WEST SUSSEX COUNTY COUNCIL CONSULTATION

TO:	Arun District Council FAO Ms M Tomalova
FROM:	WSCC - Highways Authority
DATE:	28 February 2020
LOCATION:	15-17 Kew Gardens, Bognor Regis, PO21 5RD
SUBJECT:	BR/27/20/DOC Approval of details reserved by condition imposed under ref BR/63/19/PL relating to Condition Nos 3 - dustbin storage, 5 - renewable energy, 7 - material & finishes, 10 - Construction Management Plan, 13 - cycle parking spaces, 15 - visibility splays and 16 - pedestrian visibility splays.
RECOMMENDATION:	More Information

Title:-
Proposed Site Plan (Bin & Cycle)

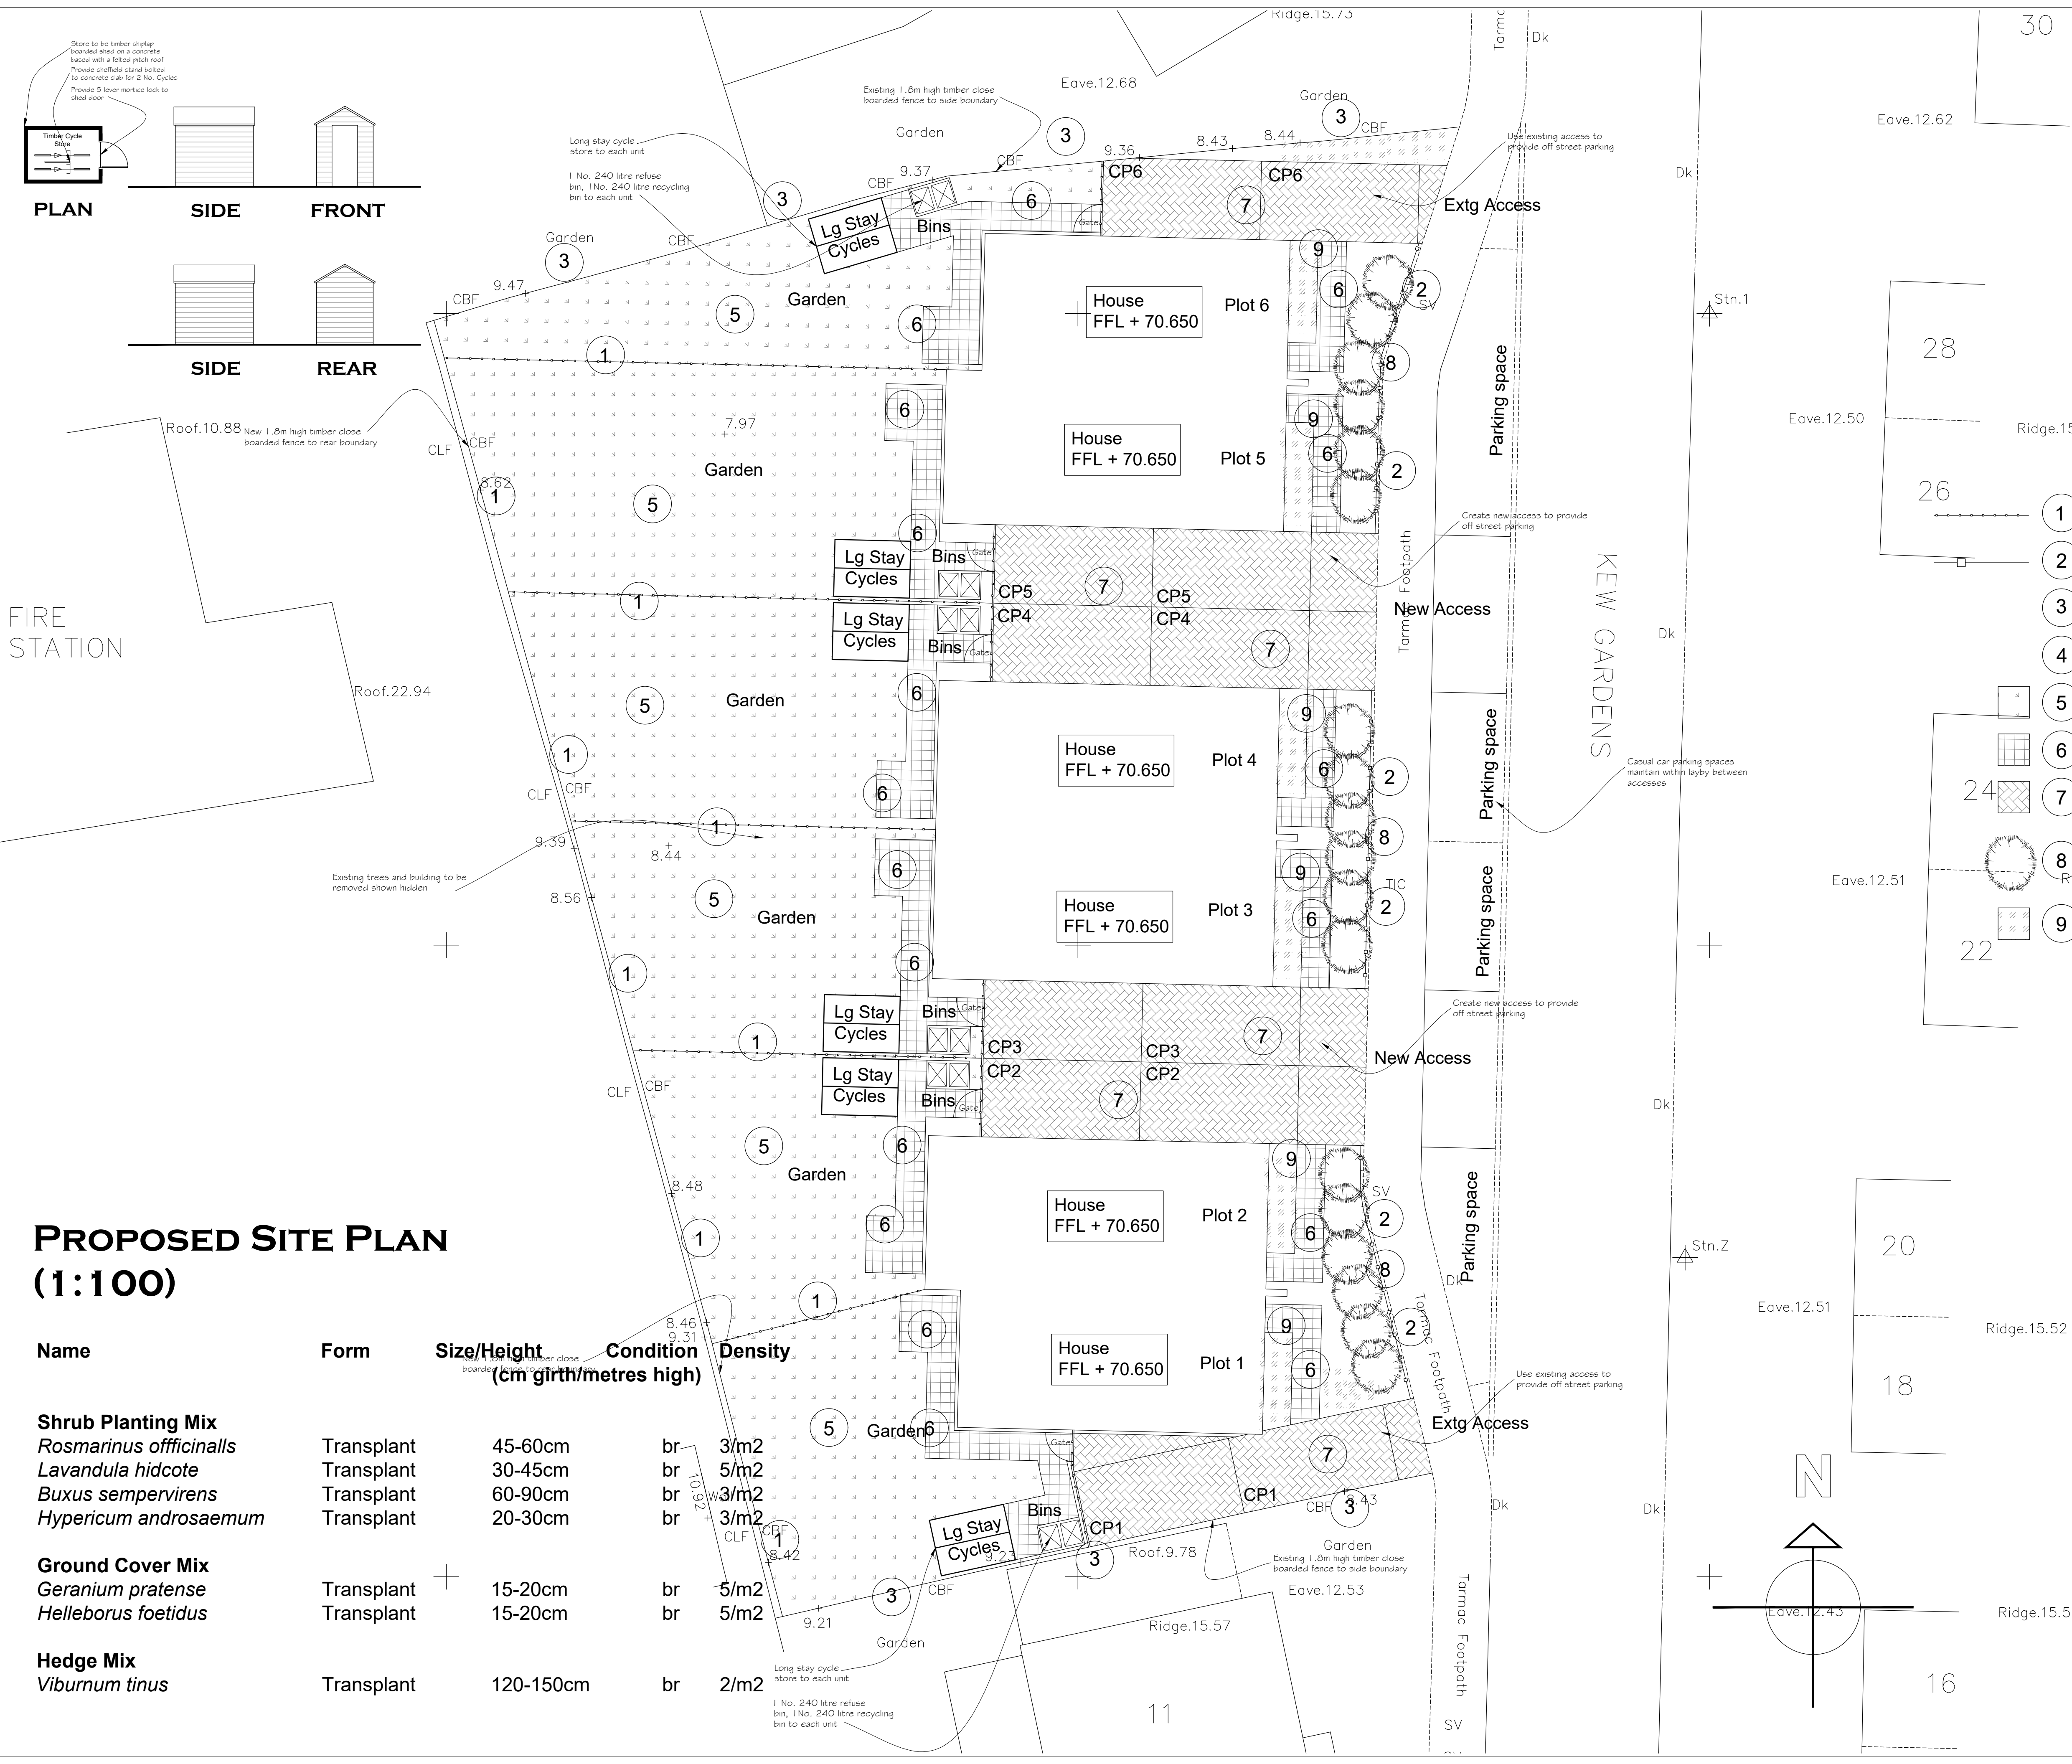
A secure and covered bicycle storage facility (shed) is indicated within rear of each plot. The plans and details pertaining to condition 13 are acceptable.

Project:-	Proposed Residential Development 15-17 Kew Gardens Bognor Regis West Sussex		
Title:-	Proposed Visibility Plan		
Client:-	Imperial Homes (Southern) Ltd		
Scale:-	1:100 (@A1)		
Drawn By:-	PJD	Checked By:-	
Date:-	09/01/20	Date:-	
Job.No:-	180037	Drg.No:-	15

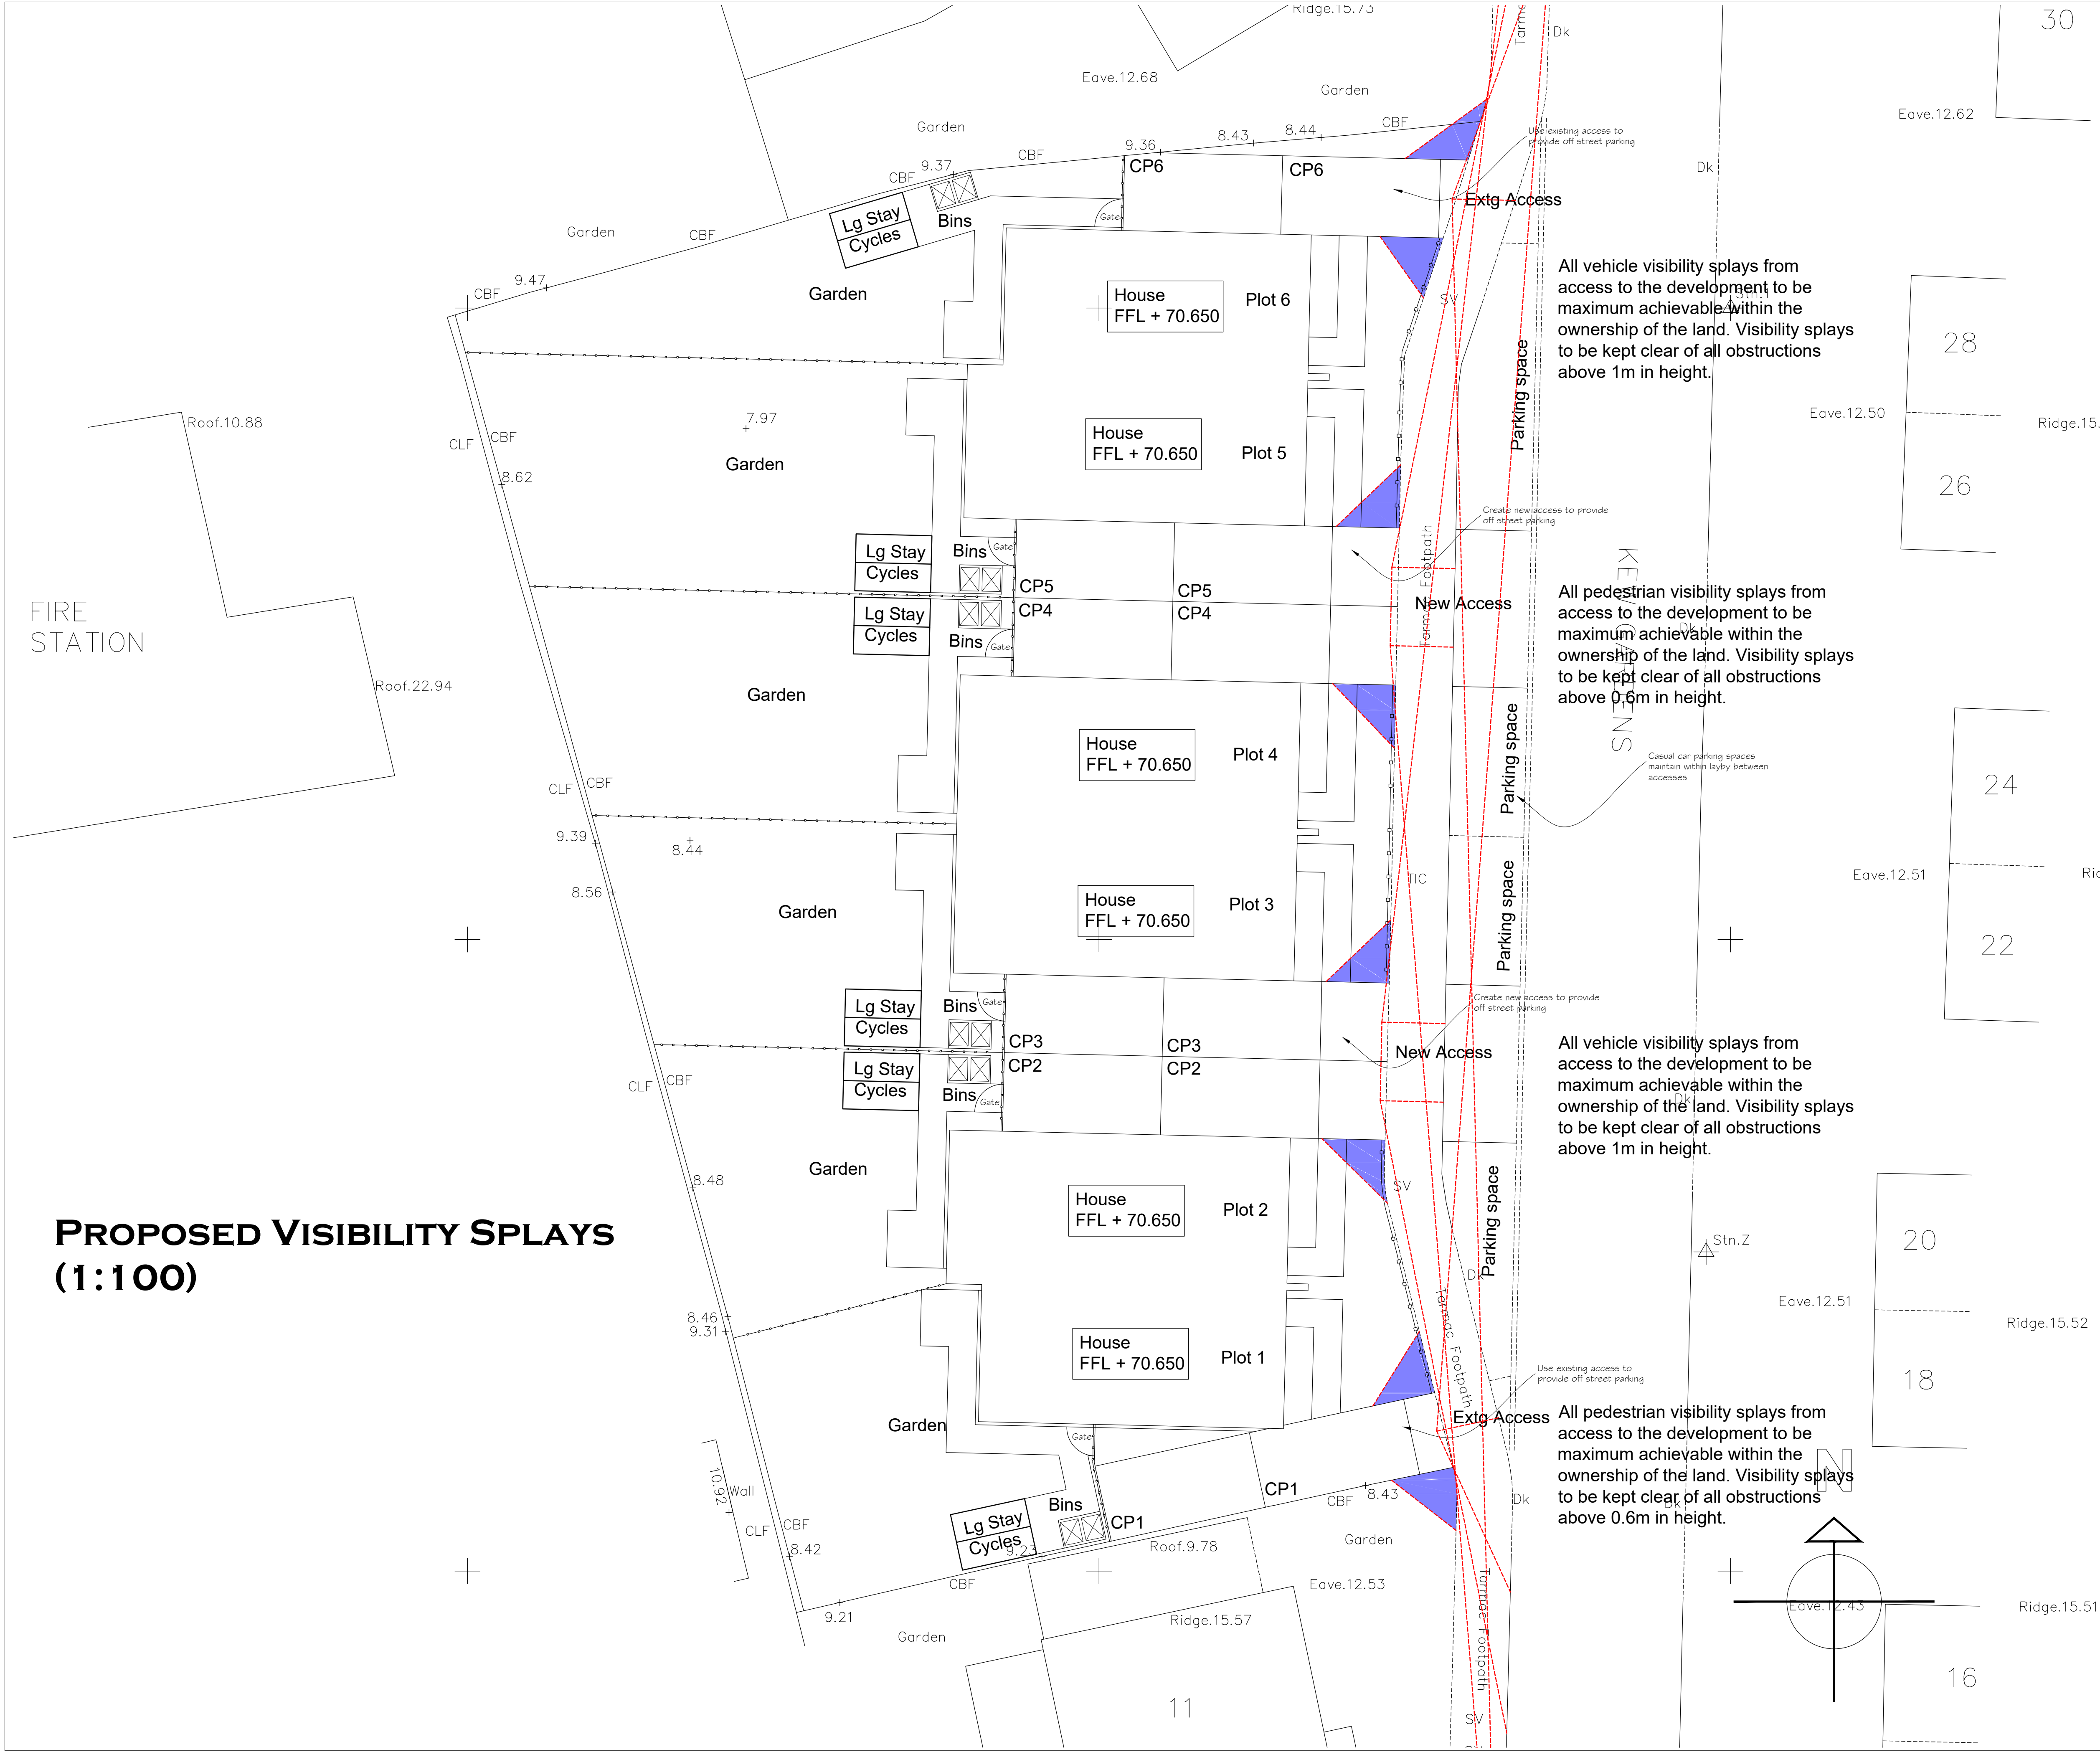
Maximum achievable vehicular visibility splays have been demonstrated from 2m back into each proposed access/car parking space. Considering the anticipated speeds and traffic levels, a 2m 'X' distance is accepted. The full extent of splays for each access point is not clear. The LHA acknowledge that the northern and southern most access points are existing however the splays for the new access points should be clearer with the full extent shown and splays achievable annotated.

The visibility splay plan indicates pedestrian visibility either side of each access. It is acknowledged that the furthest south and north splays are outside red edge of the site -

these should only be shown in land under applicants control. Please amend the plan accordingly.

- type of construction vehicle and frequency anticipated along with omission of 'vehicle turning' from the plans (unless turning has been demonstrated)
- show full extent of maximum achievable splays for **new** access points and annotate these.
- make red edge of site clear on the visibility plans and omit pedestrian visibility splays where these are outside of red edge
